PLANNING STATEMENT

22022 – 2 Whitebeam Road, Oadby, Leicester, LE2 4EA

This planning statement has been carefully produced to support an application for planning permission on behalf of Mrs. Bhalla. The application is for a double storey side and rear extensions, single storey front and rear extensions, garage conversion and roof alterations at 2 Whitebeam Road, Oadby, Leicester, LE2 4EA.

Drawing Name:
PROPOSED SITE PLAN

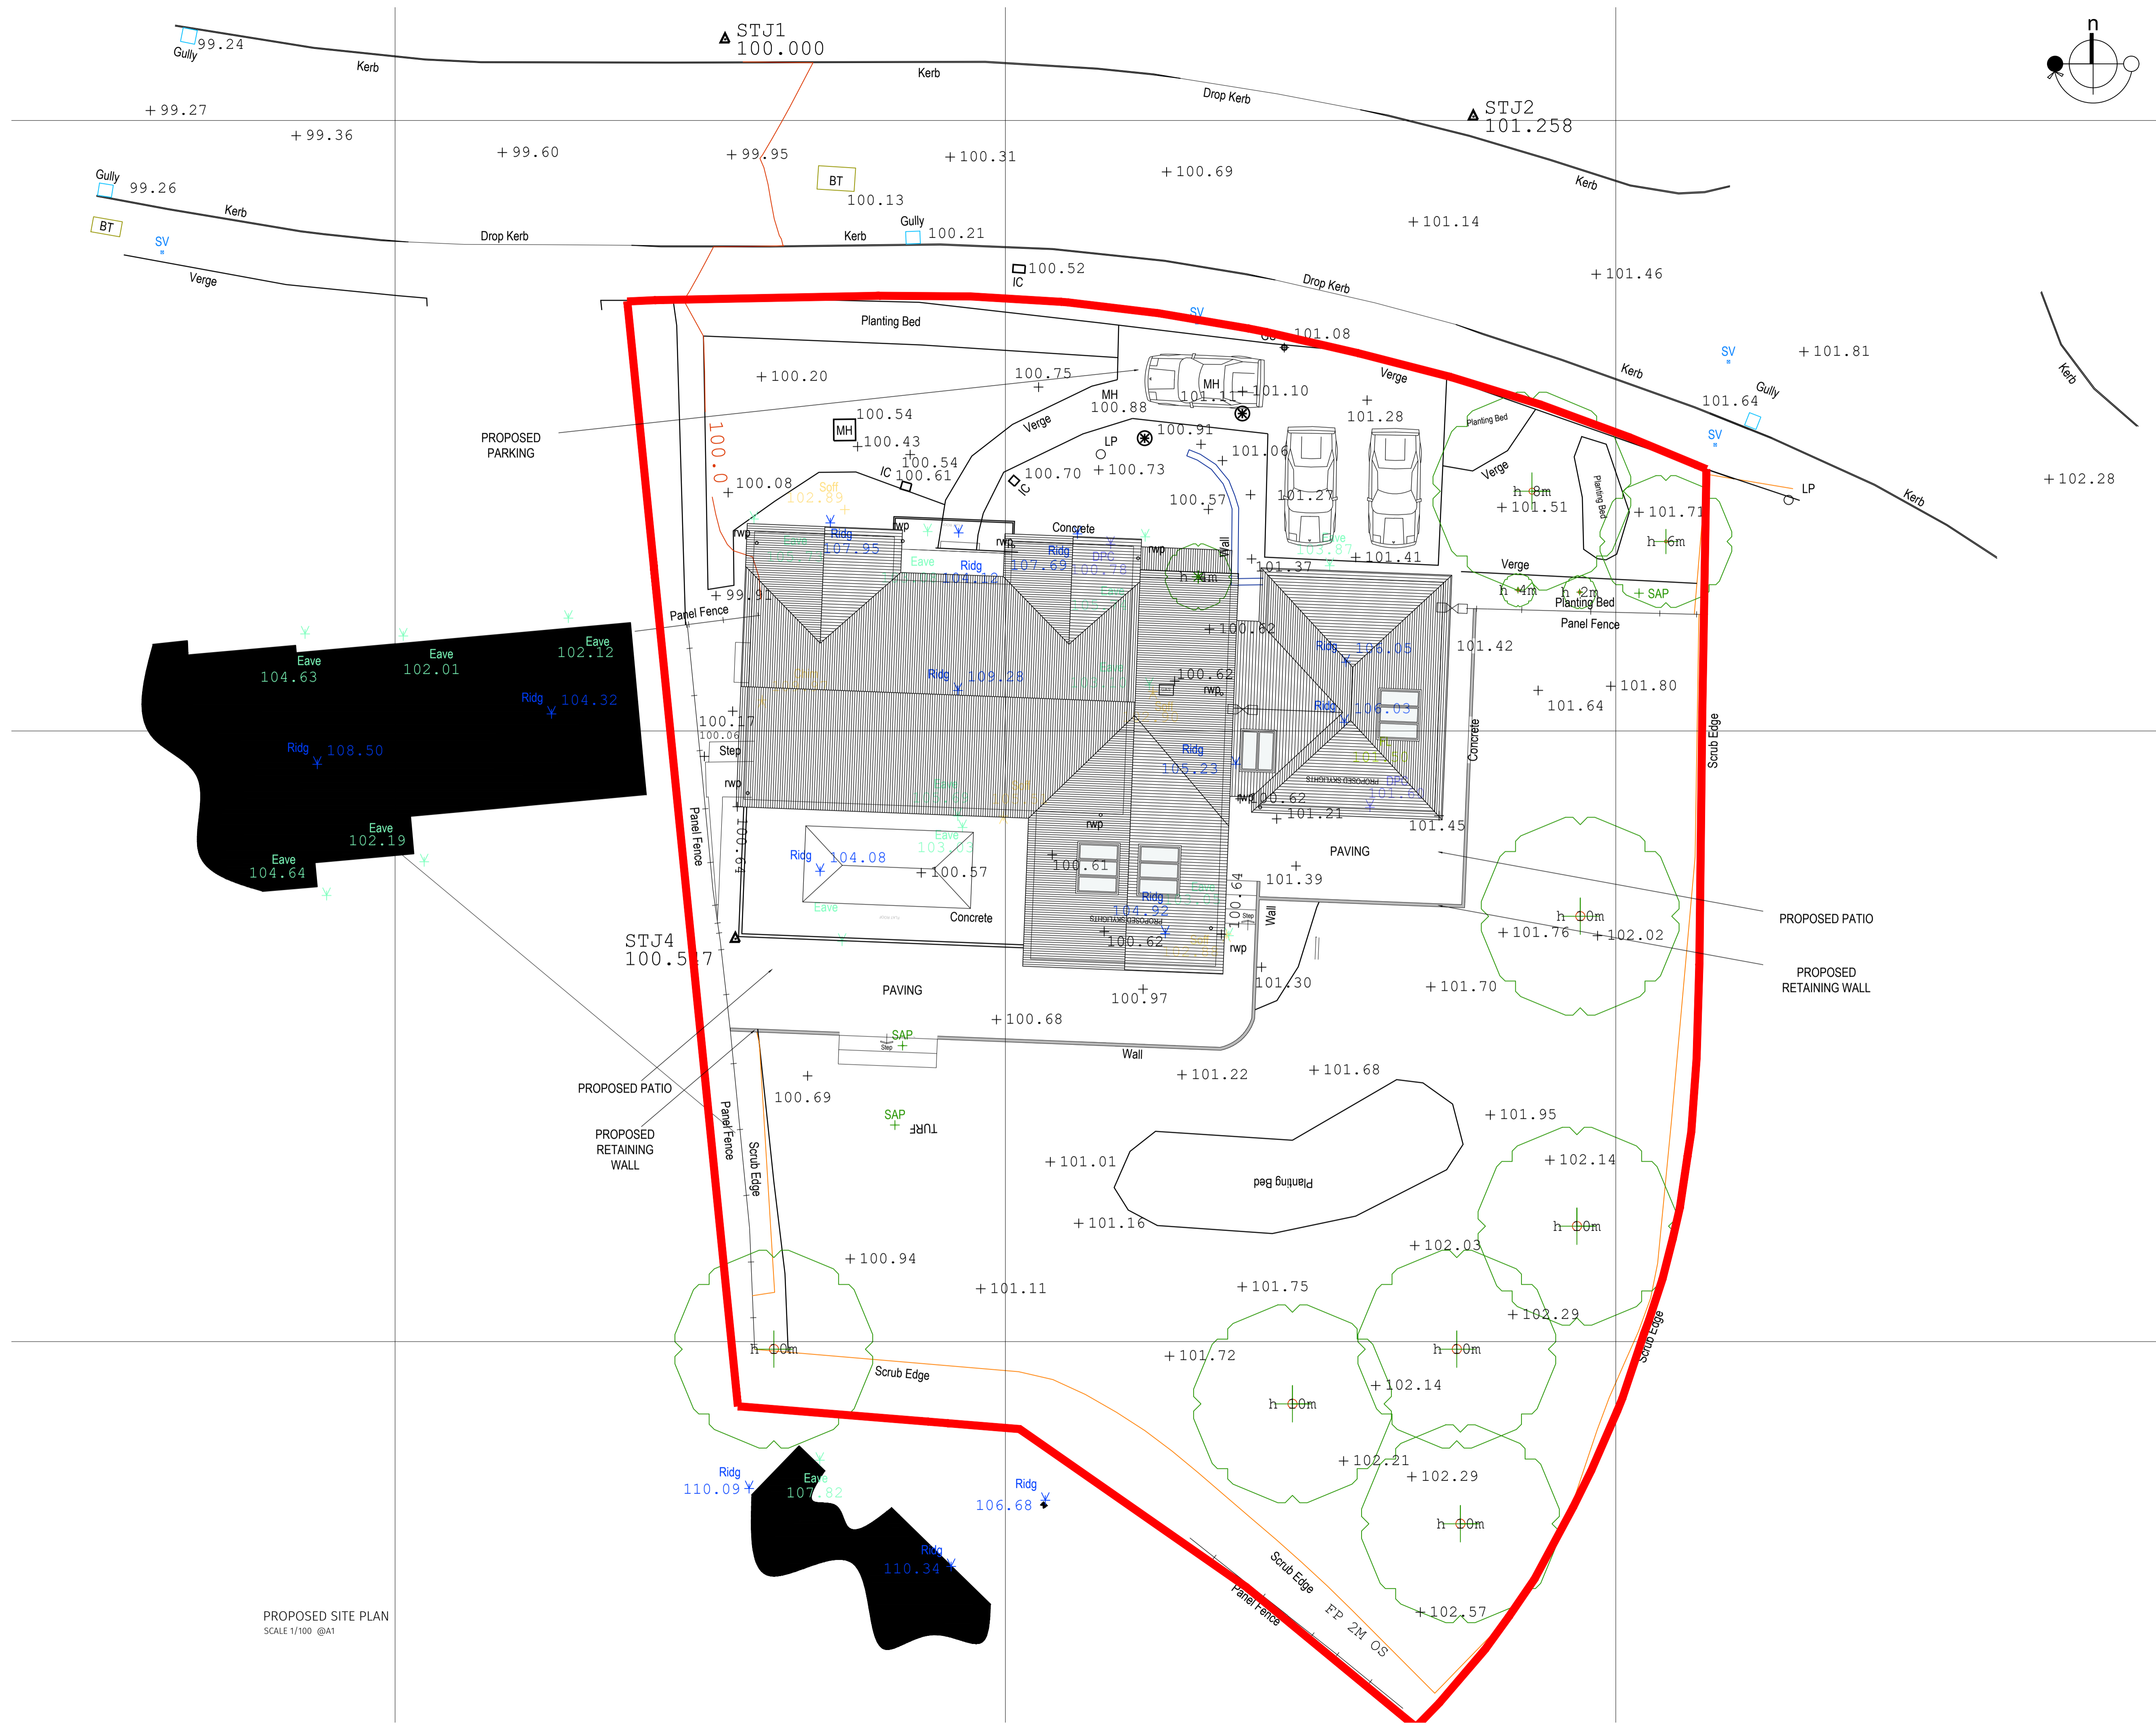
Reason 1: The proposals would significantly overextend the original property and would result in a building that is overextended and out of keeping with the rest of the street scene.

Our response: In response to this concern, we have reduced the width of the two-storey side and rear extensions as well as removing the detached garage. This is visually illustrated in the figures 5 and 6.

PROPOSED FRONT ELEVATION
SCALE 1/100 @A1

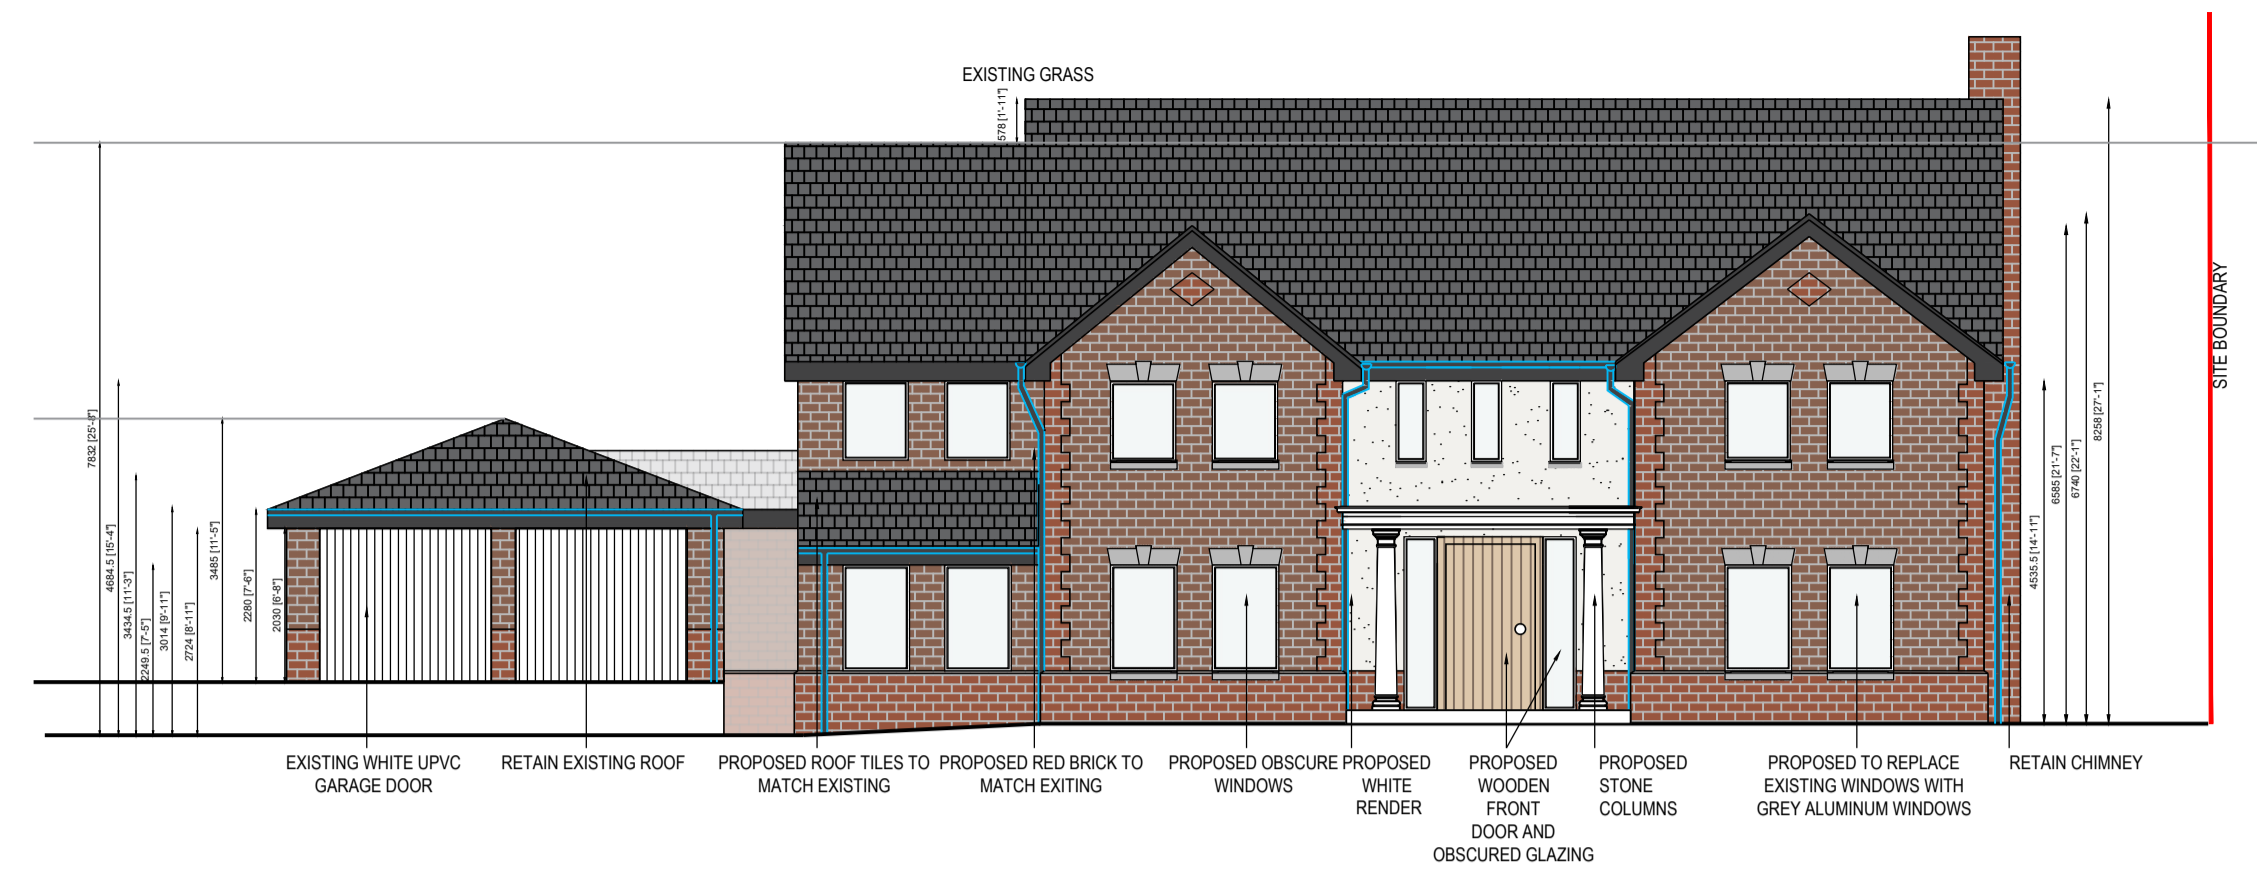
Reason 2: The creation of a catslide roof at the front with large roof lights and an overly dominant porch isn't in keeping with the design of the existing property or street scene.

Our response: To address this matter, we have changed the porch design to a flat roof with columns to hold it up. This sits well in the street scene as many properties have this style as seen in the images below.

PROPOSED REAR ELEVATION
SCALE 1/100 @A1

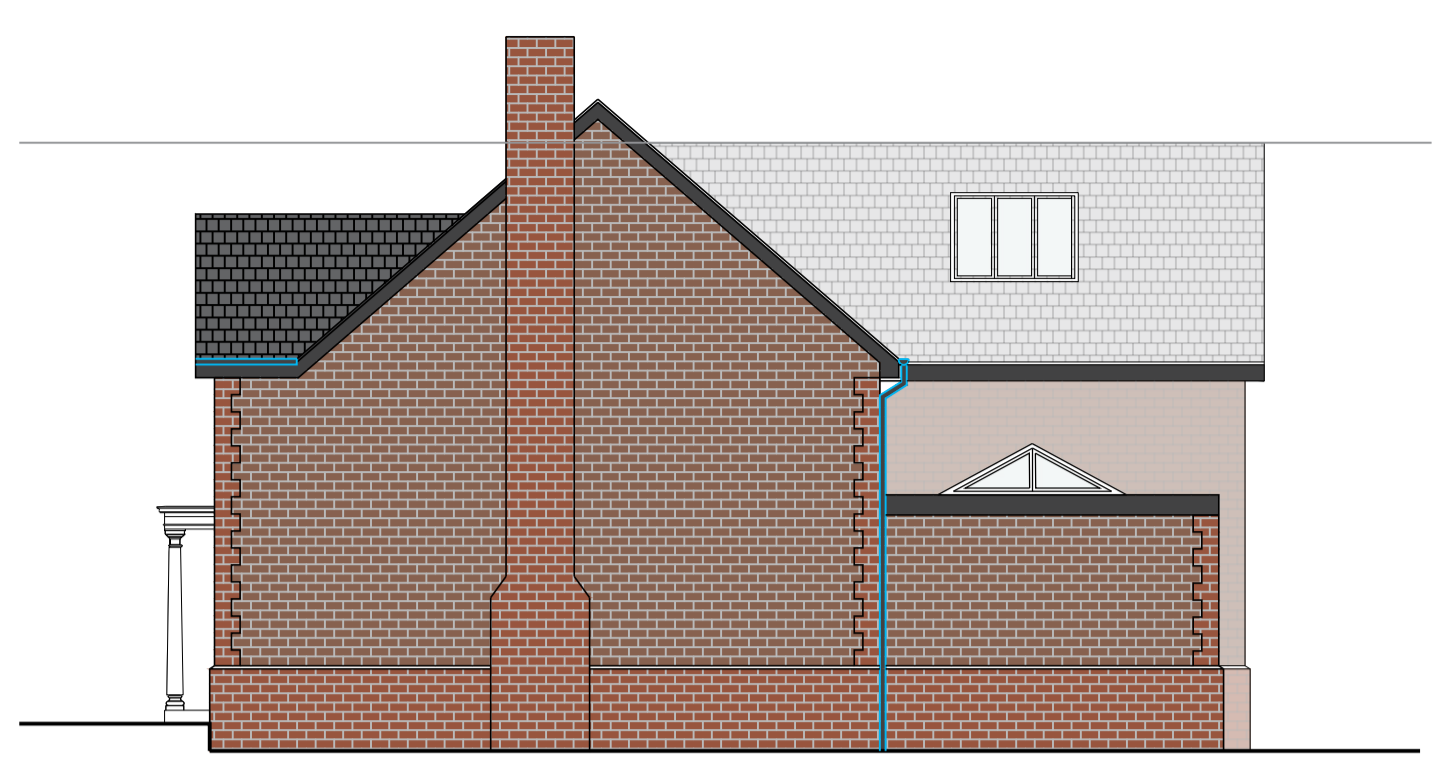
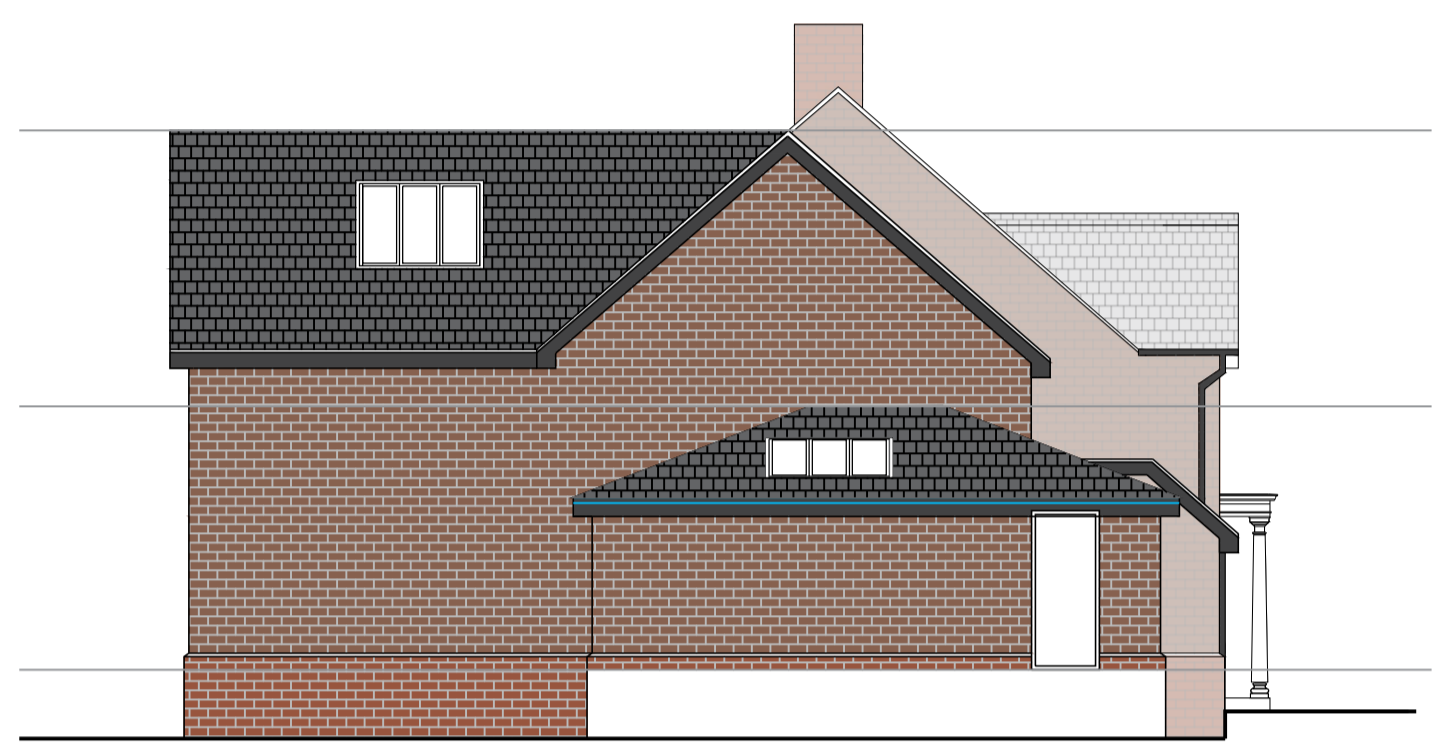
Reason 3: The proposed two storey rear extension cut across both the existing rear and proposed side extension.

Reason 5: The use of glazed gables to the rear isn't in keeping with the fenestration of the existing property.

Reason 10: Flat roofs can often appear as incongruous features inconsistent with the design of the roof on the existing house, and notwithstanding that these extensions are on the rear, they would be visible from public viewpoints along Stoughton Road through the boundary vegetation, especially in the winter months.

Our response: After considering this issue, we have decided to retain this element as it does not have a visual impact to the neighborhood. The below image (figure 8) shows how by the surrounding vegetation screens our applicant's property.

Our response: We have taken this concern into consideration; however, we decided to retain this feature. An example of glazed gables is available in the estate, an example to support this statement is shown below in figure 9. The property on Hawthorn Road is located only a three-minute walk from our property at 2 Whitebeam Road. This property portrays a side glazed gable design similar to ours.

Our response: Whilst taking this issue into consideration we have retained the flat roof designs as it is hidden from public viewpoints from Stoughton Road via the vegetation boundary as seen in figure 14. An example being the property on Hawthorn Road (shown in figure 9). Flat roof extensions are also considered acceptable under permitted developments. Furthermore, 72 Stoughton Road property, situated at the entrance of the Road highlighted in red in figure 15, rear to our client's property (highlighted in blue) has a glass gable feature as well as a balcony which is visible from both the road and the 2 Whitebeam Road's property. This is not hidden from public viewpoints, therefore the extension on Mrs Bhalla's property is reasonably acceptable.
